From: [REDACTED]
Sent: 06 June 2018 22:54
To: Amber Willard
Subject: RE: Local Highway Authority Response

Thanks for sending across this revised plan (18/07/3).

I attach the requested plan for re consultation as requested for LU/81/18/HH.

DRAWING	SCALE
BLOCK PLAN	1/200
DATE: MARCH 2018	
DRAWN: T. Murray	
DRAWING: 18/07/3	REVISION:

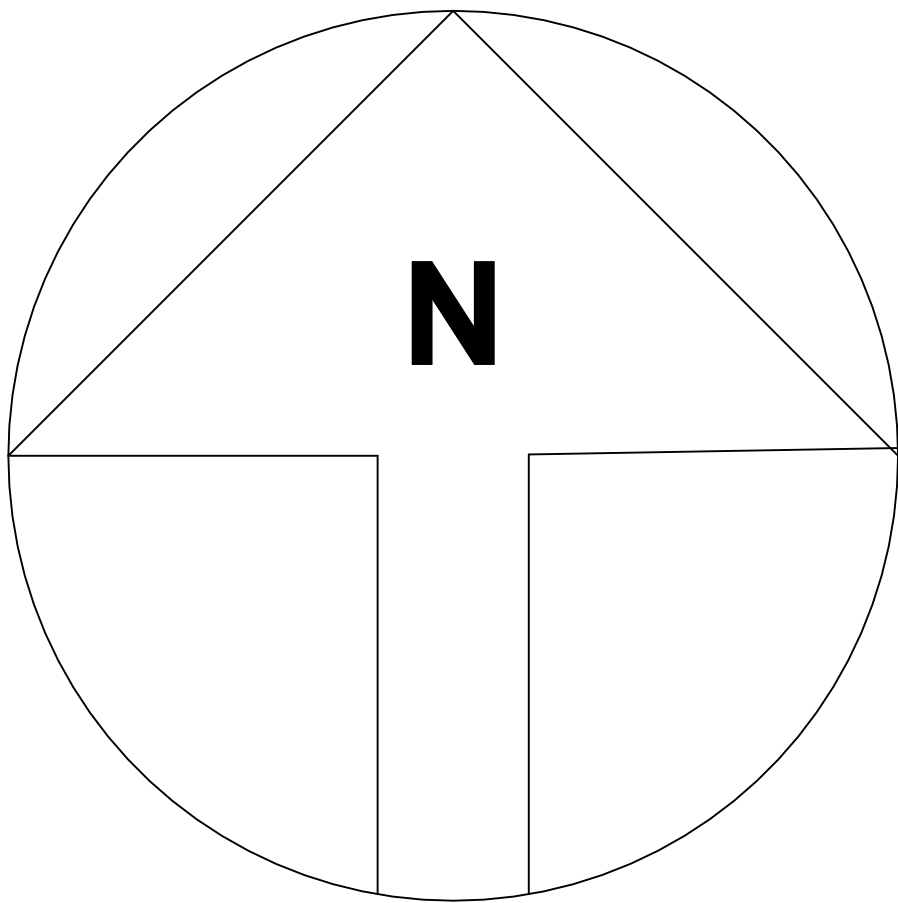
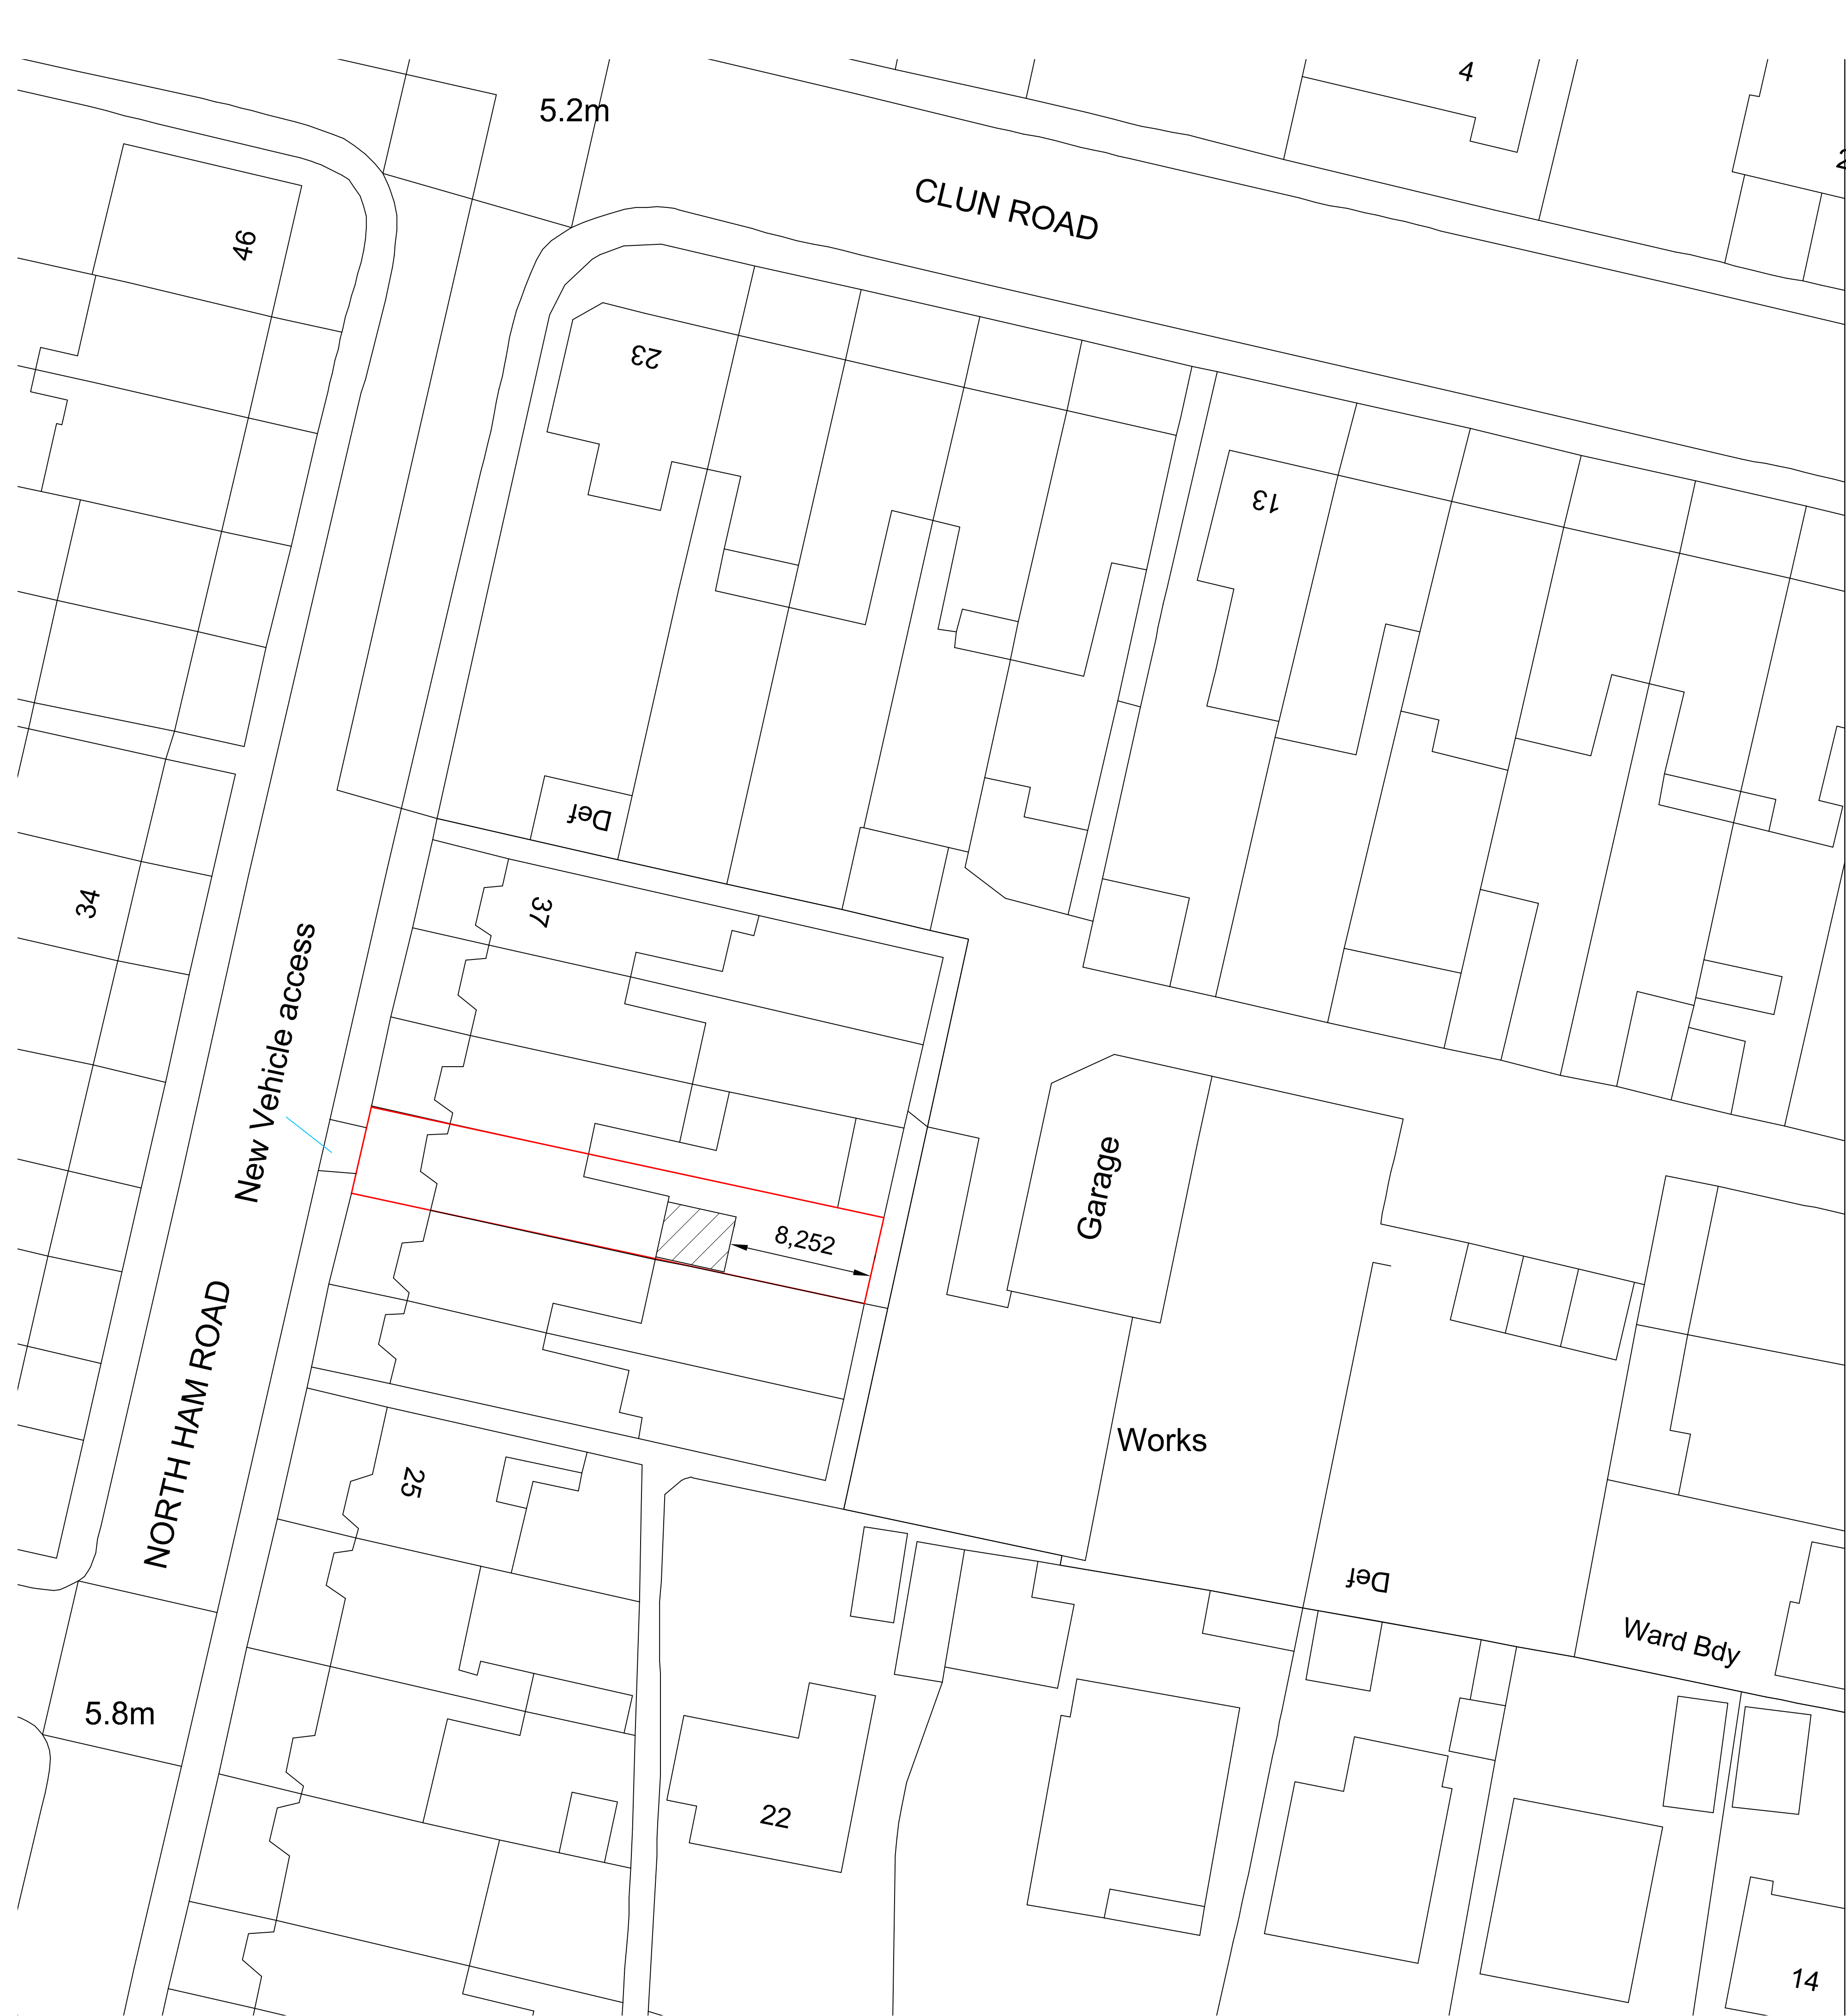
I can advise that for a vehicle to be fully removed from the carriageway / footway perpendicular off street car parking spaces should measure a minimum of 2.4 x 4.8 metres. Parallel spaces should measure a minimum of 2 x 6 metres, however this is only if both sides of a vehicle would be accessible, otherwise a space of 2.4 x 6 metres would be more appropriate.

After inspection of the revised plan the area of hardstanding will equate to a maximum of 3.5 metres (dwelling to footway) x 5.1 metres (north/south boundary). The area of hardstanding would therefore be below these recognised standards for both a perpendicular or parallel park.

I have consulted with the Highway Engineer for this area and I have been advised that similar application for vehicle crossovers in this locations have been refused for the reason stated above. I would not anticipate a licence application for this crossover being granted.

For the reasons above it is advised that the vehicle crossover and hardstanding element of this application is removed from the current planning application.
